Comprehensive Preliminary Review

Environmental Impact Assessment Report

Lemanaghan Wind Farm, Co. Offaly

An Coimisiún Pleanála Reference: 200804

PROJECT TITLE:			
<b>Lemanaghan Wind Farm, Co. Offaly</b>			
DRAWING TITLE:			
<b>Bored Pile Foundation Details</b>			
PROJECT No.:	DRAWING No.:	SCALE:	
<b>200804</b>	<b>Figure 4-6</b>	<b>As shown @ A3</b>	
DRAWN BY:	CHECKED BY:	DATE:	REVISION:
<b>FB</b>	<b>GO</b>	<b>23.03.2026</b>	<b>P01</b>

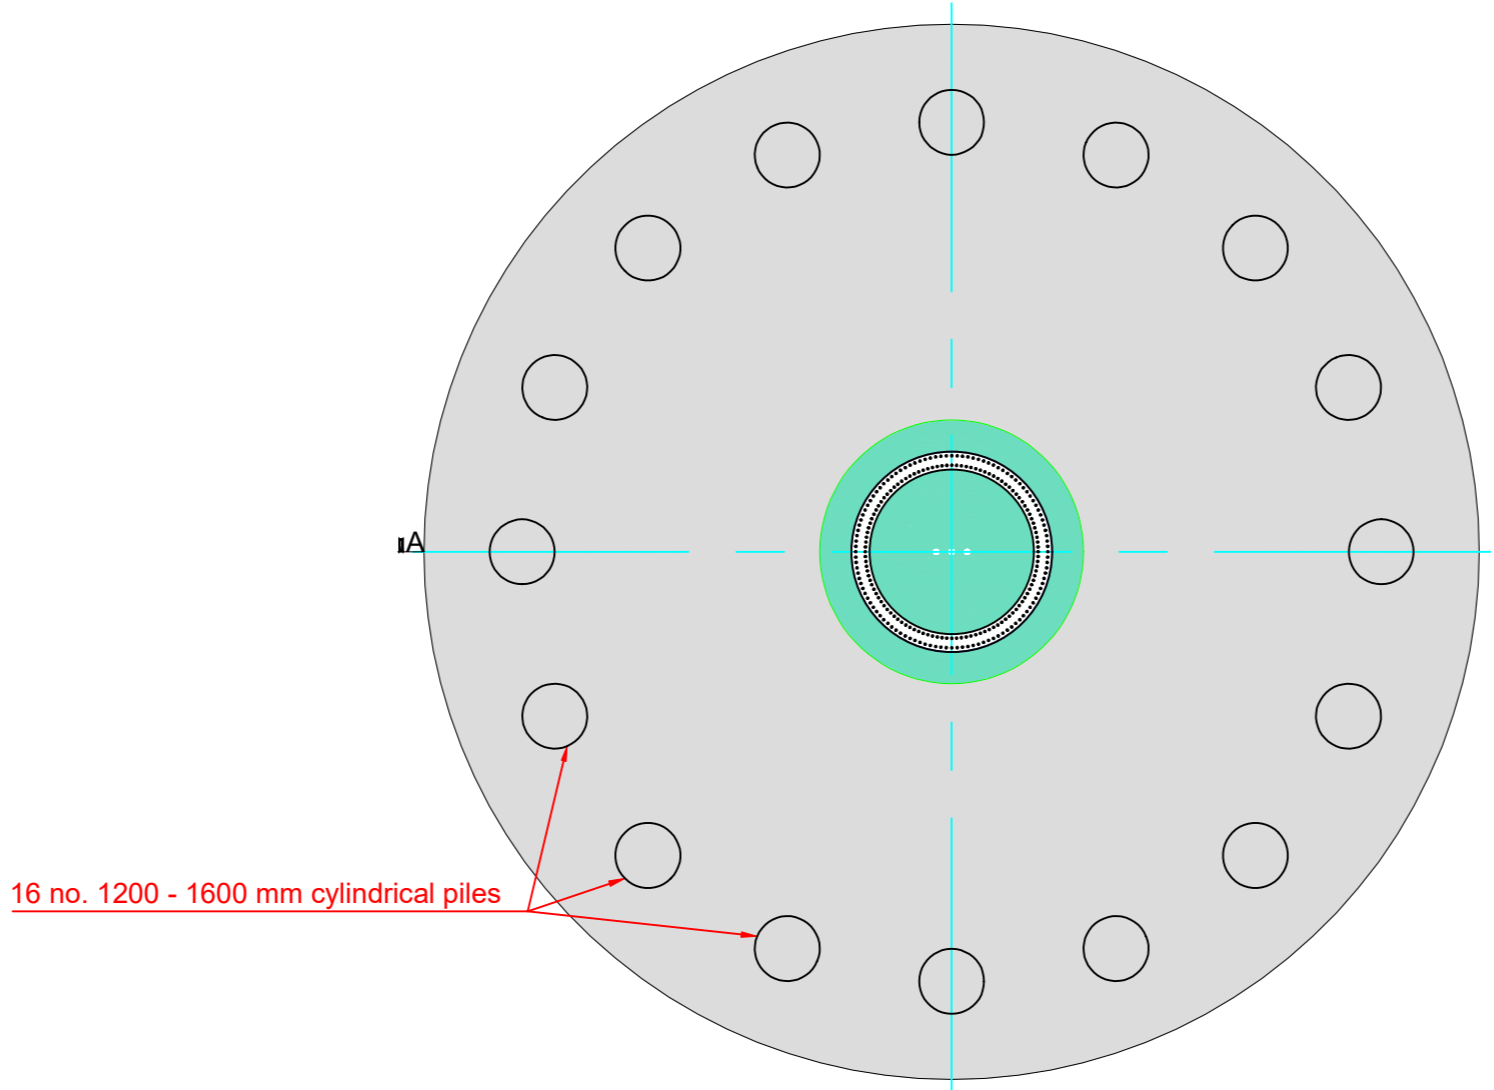
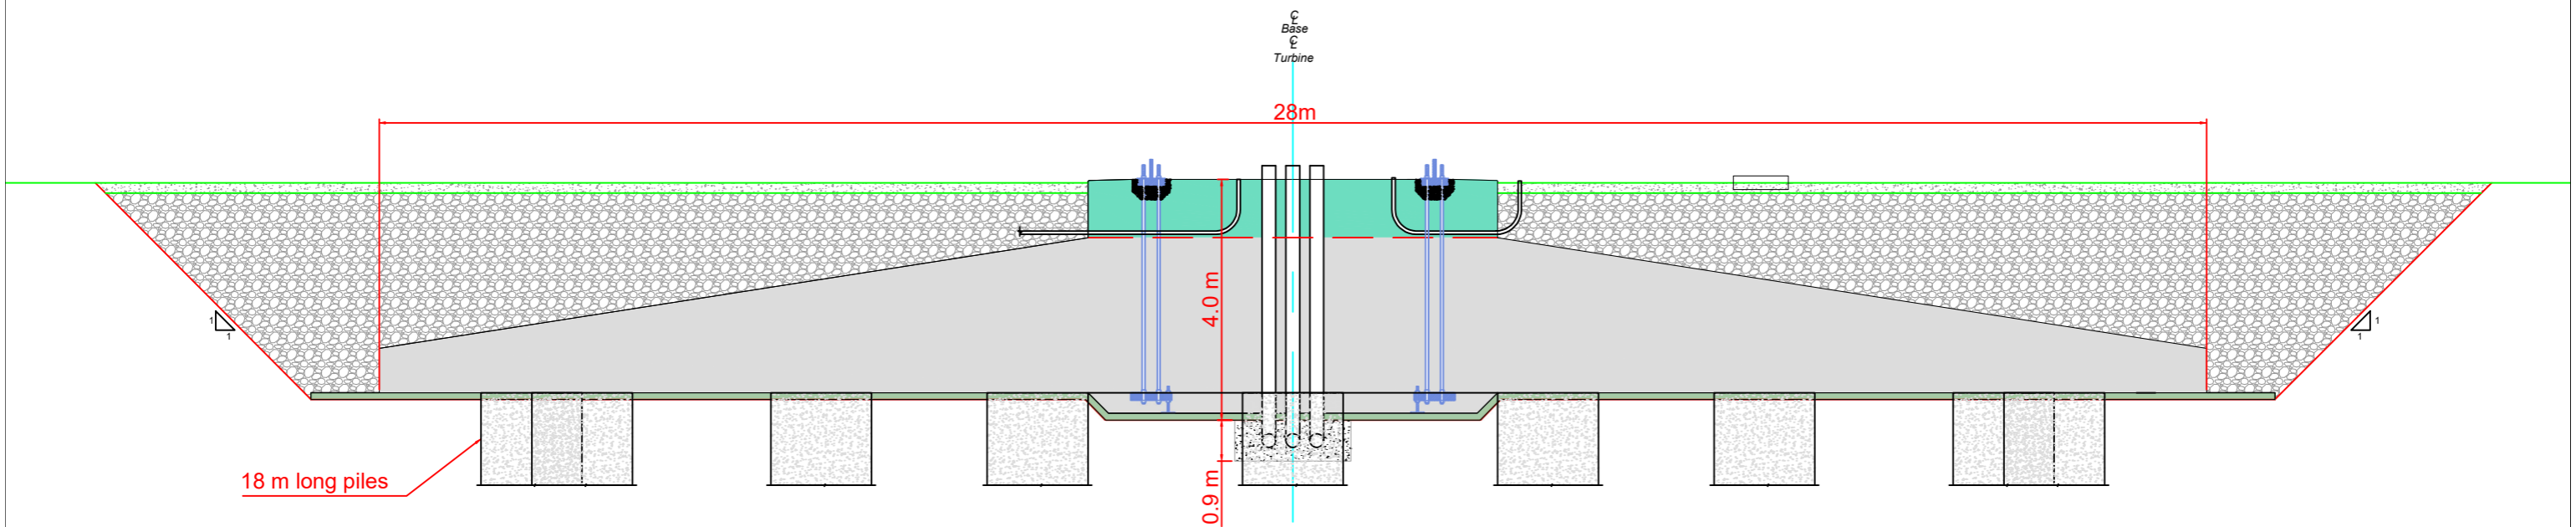
The EIAR (Ch.8, Table 8-5) reports peat depths at turbine locations ranging from 0.10m to >6.2m, with the deepest deposits at T15 and T1. However, the carbon footprint assessment treats the 34.3 ha permanent footprint as a single undifferentiated area and concludes that its loss is 'negligible.' This approach fails to account for the non-linear relationship between peat depth and carbon stock — deeper peats contain exponentially more carbon than shallow peats.

- 9.3 km of Type A excavated roads founded on mineral ground — acting as linear drainage features intercepting groundwater and surface runoff
- 12.1 km of Type B floating roads covering peat surfaces with up to 1.0m of granular fill — creating impermeable barriers to surface water movement
- 15 turbine foundations (32m diameter, to mineral ground) — creating permanent drainage sumps within the peat body

A turbine-specific, depth-weighted carbon stock calculation should be prepared using measured peat bulk density and carbon content from each turbine location's borehole and trial pit data.

Sections of New Excavated Roads are shown in Figure 4-10 below.

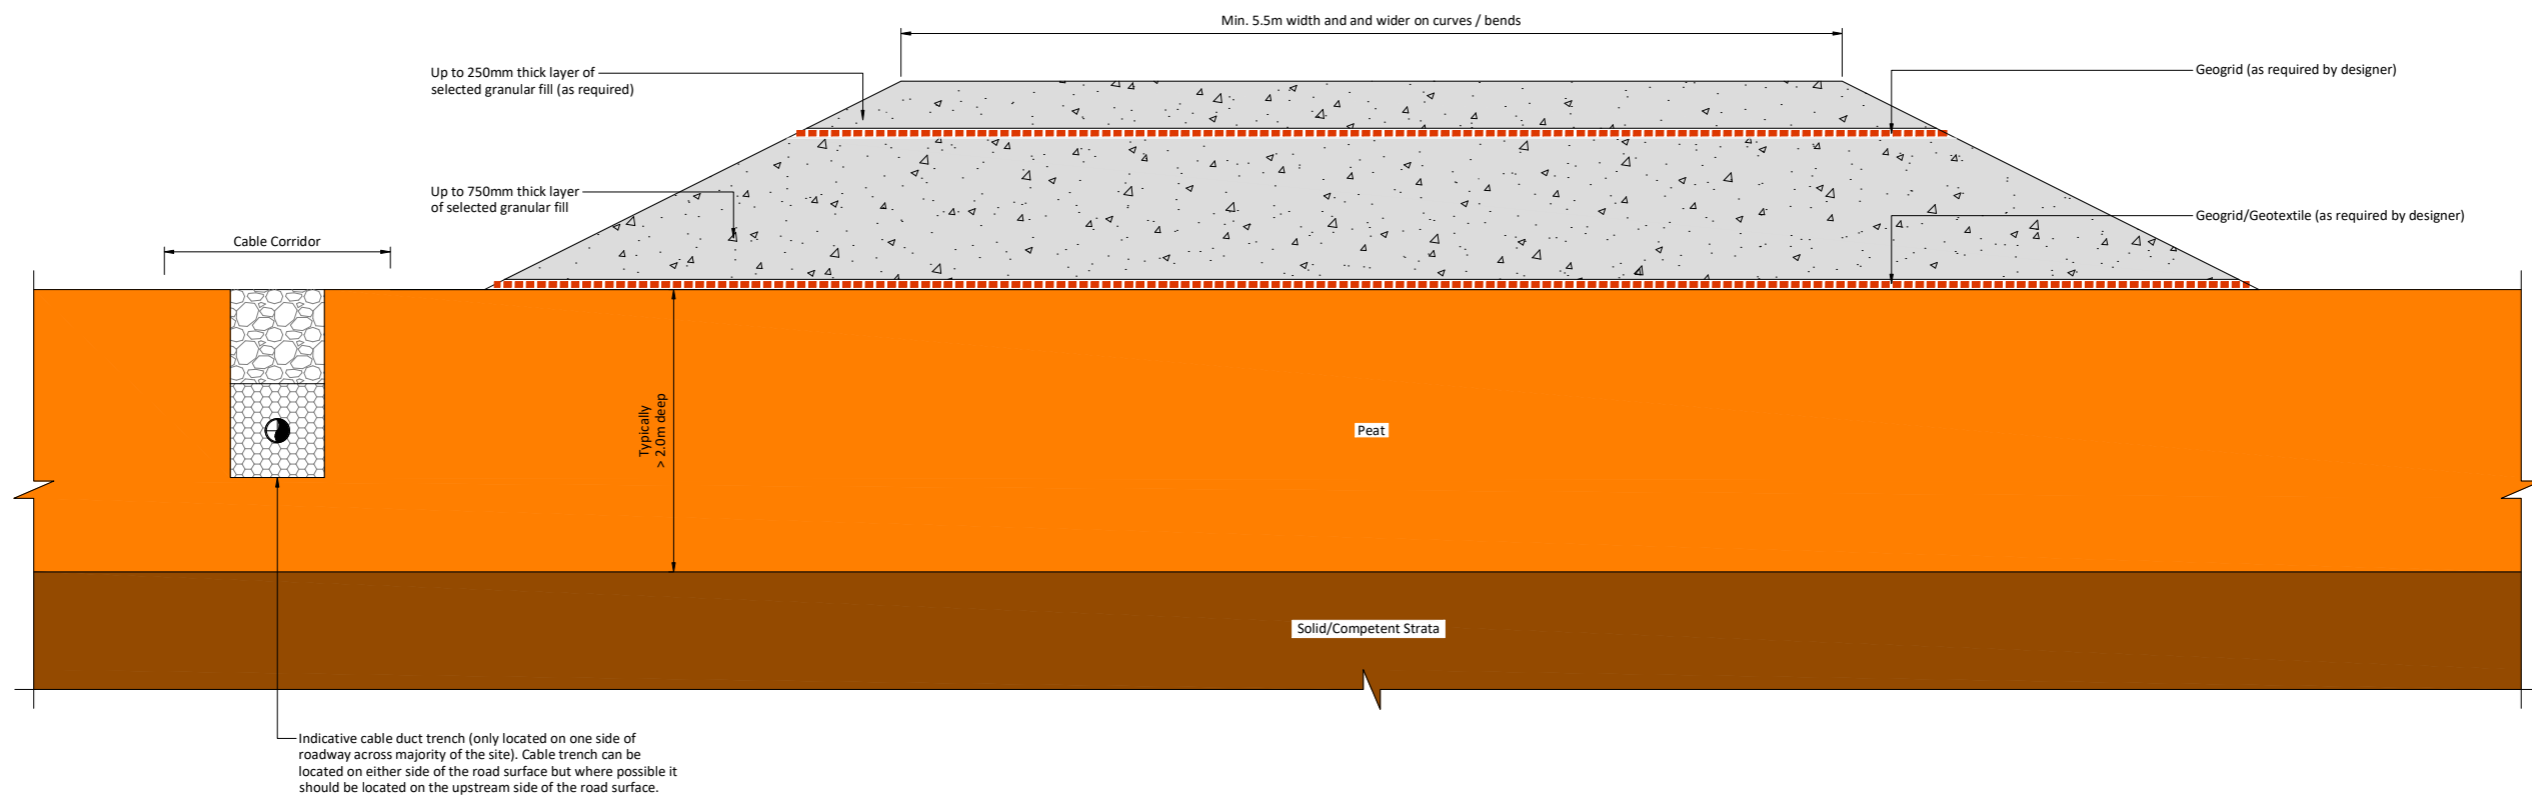
The EIAR acknowledges that 'lands adjacent to the Proposed Wind Farm footprint may also be indirectly impacted through drainage and therefore also not reach their carbon sequestration potential' (NTS, p.xxviii), but provides no quantification. The 9.3 km of Type A excavated roads (App.5, Table 2-1) function as effective linear land drains. The literature demonstrates that hydrological influence can extend 20–50m laterally from excavated roads into flanking peat (Holden et al., 2006; Wilson et al., 2011). A 9.3 km road with a 20m bilateral influence zone would affect approximately 37 additional hectares of peat, unaccounted in the 34.3 ha permanent footprint.

A hydraulic modelling exercise should estimate the extent of peat drainage influence from all Type A roads. The carbon balance should include ongoing annual CO₂ flux from this indirectly affected area using appropriate Irish peat drainage emission factors.
